Freedom Forever
Planset Revision Letter

12/3/2024
REV #2

Attn. County of Harnett (NC):

SPENCER RICHARD
44 JACK HARRIS LN

PROJECT DETAILS

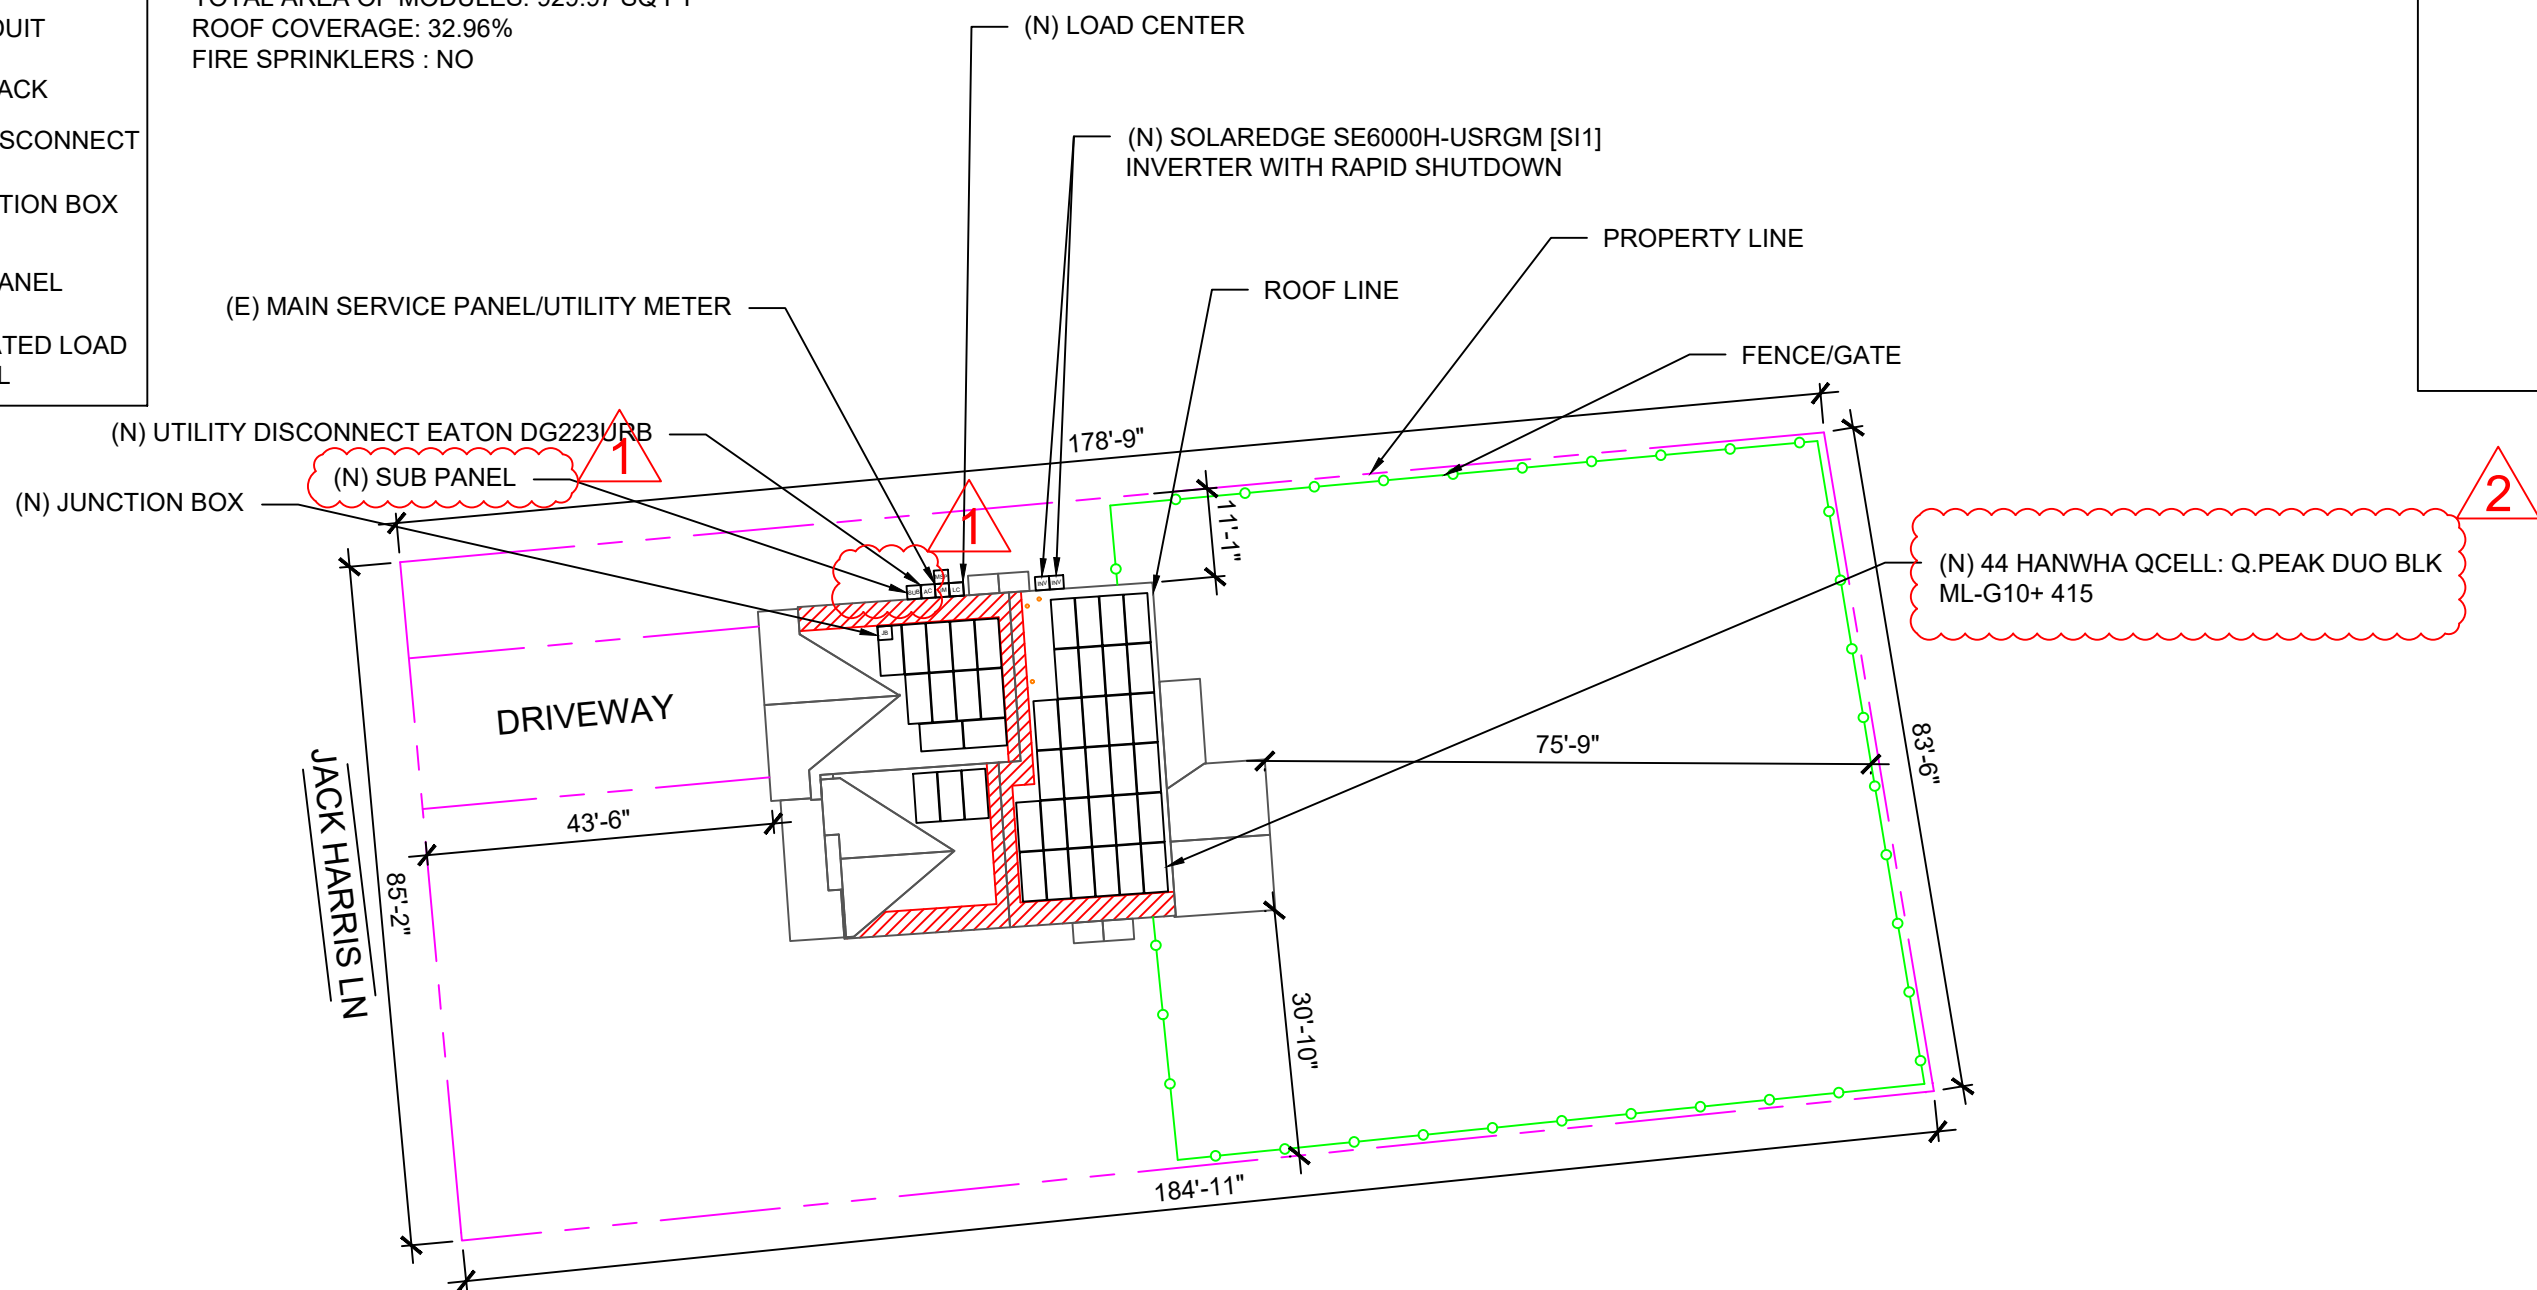
Mod swap to Qcell 415's

MOUNTING DETAILS			
JOB NO:	DATE:	DESIGNED BY:	SHEET:
502646	12/3/2024	A.A.	PV-3

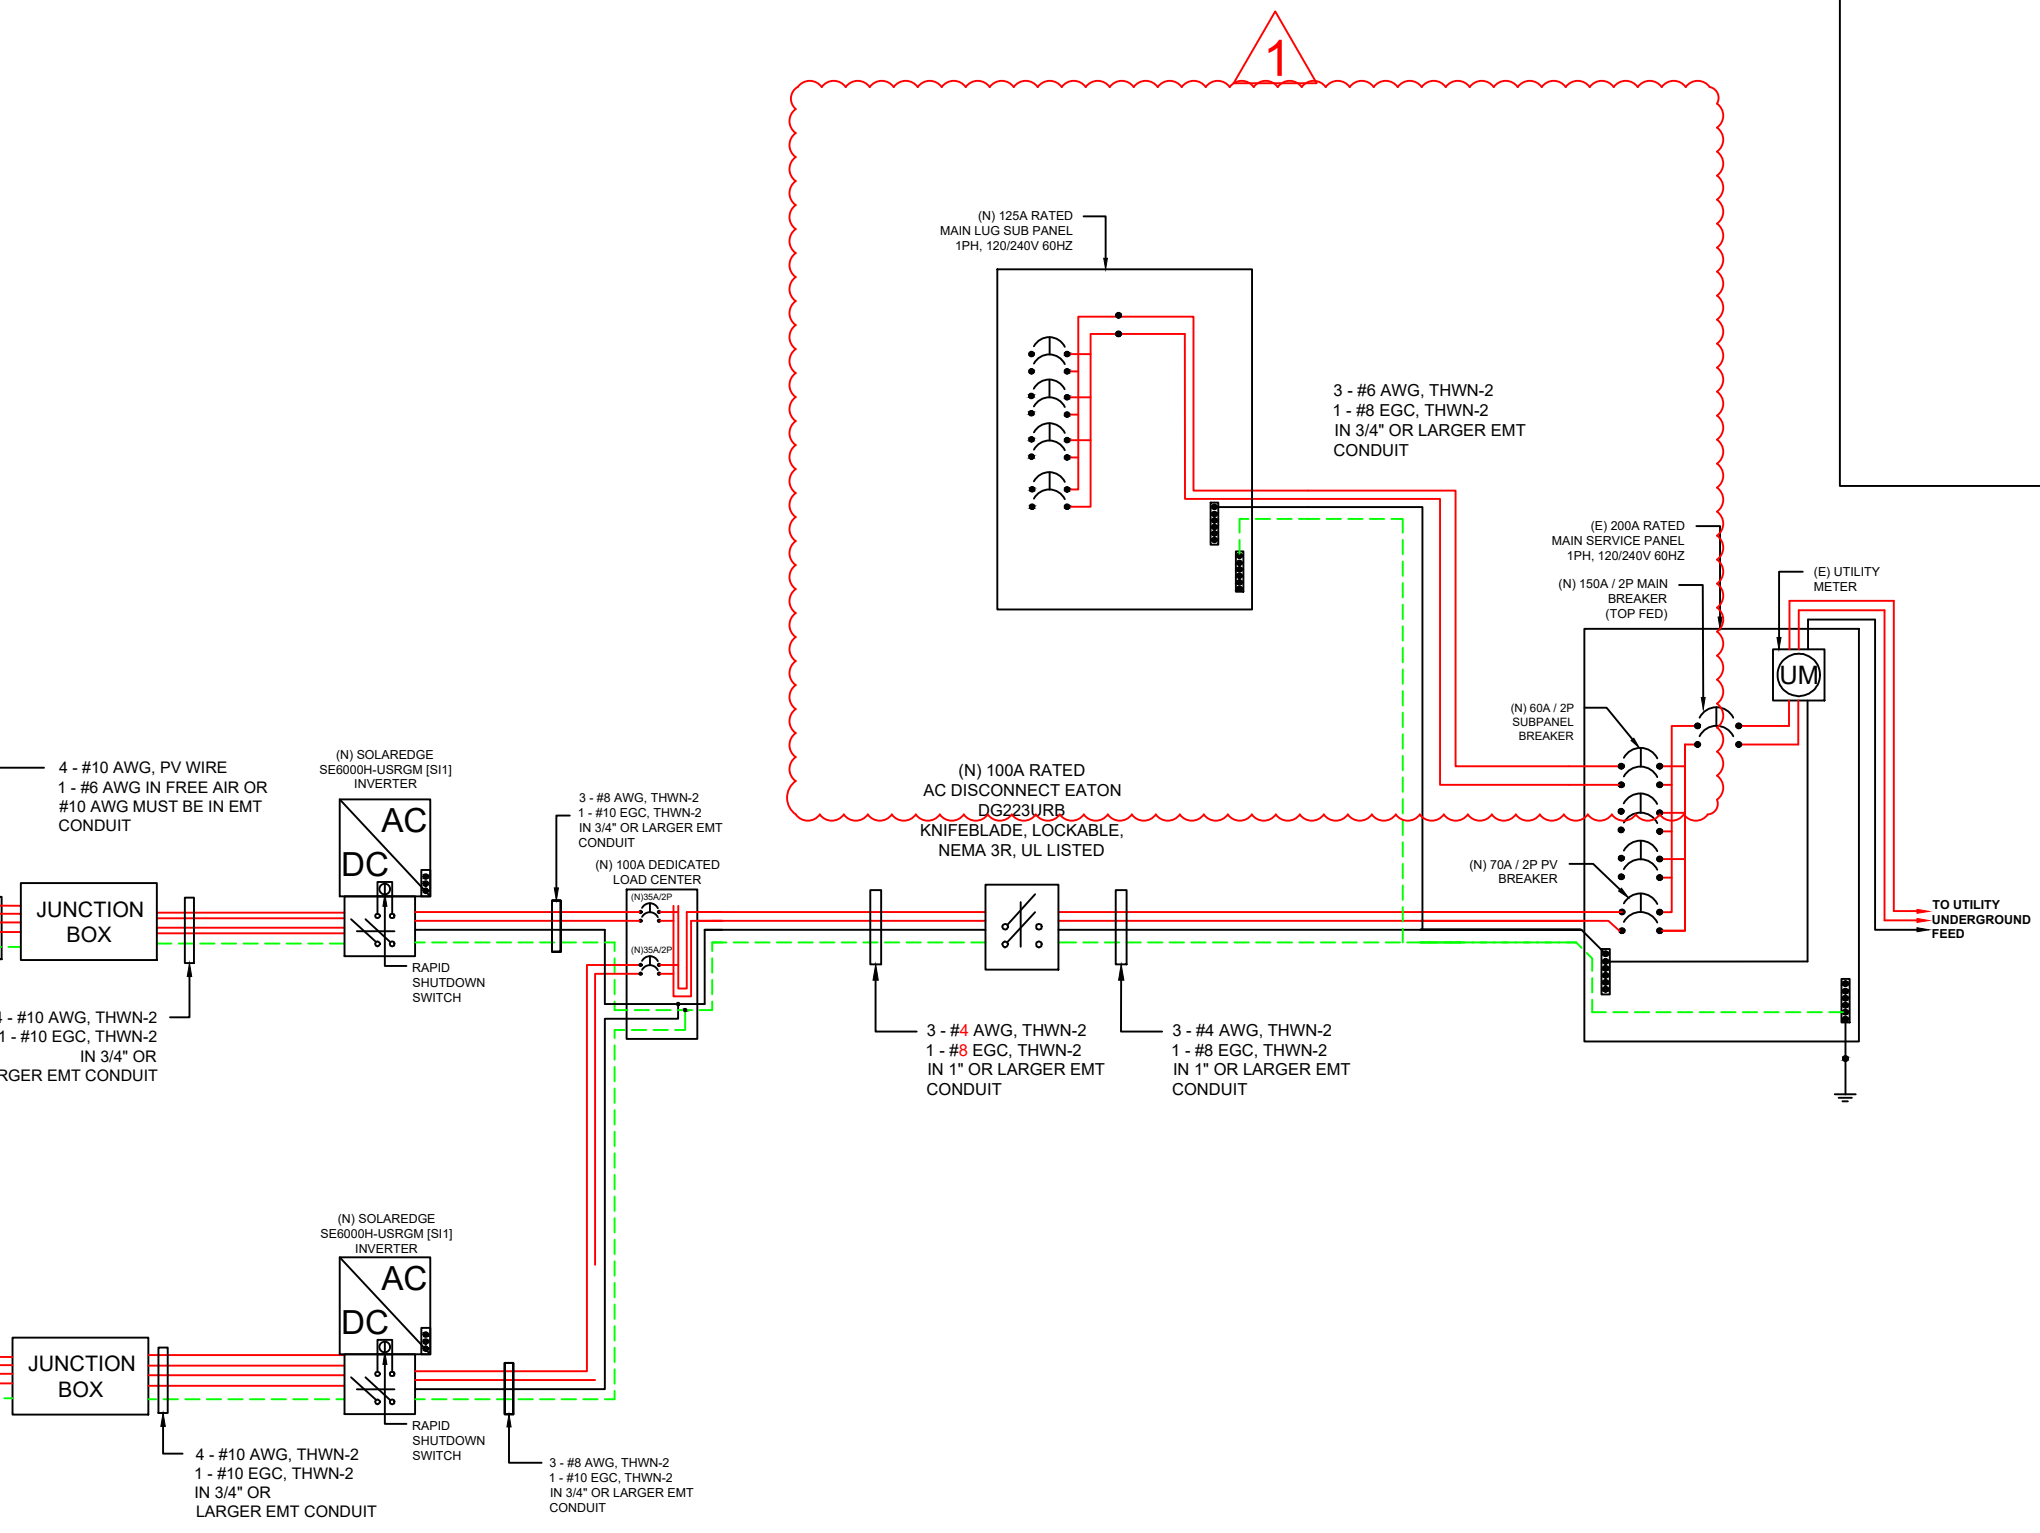
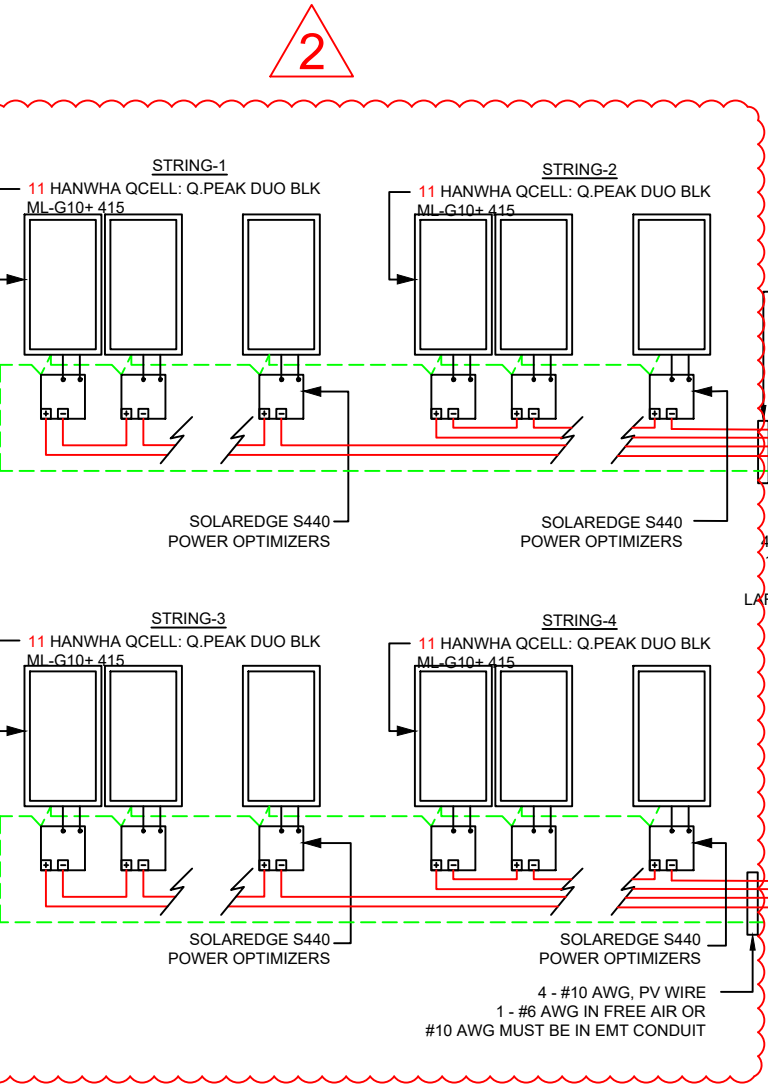
Added New 125A Rated Subpanel Insert/60A Feeder breaker to make room for PV breaker in MSP
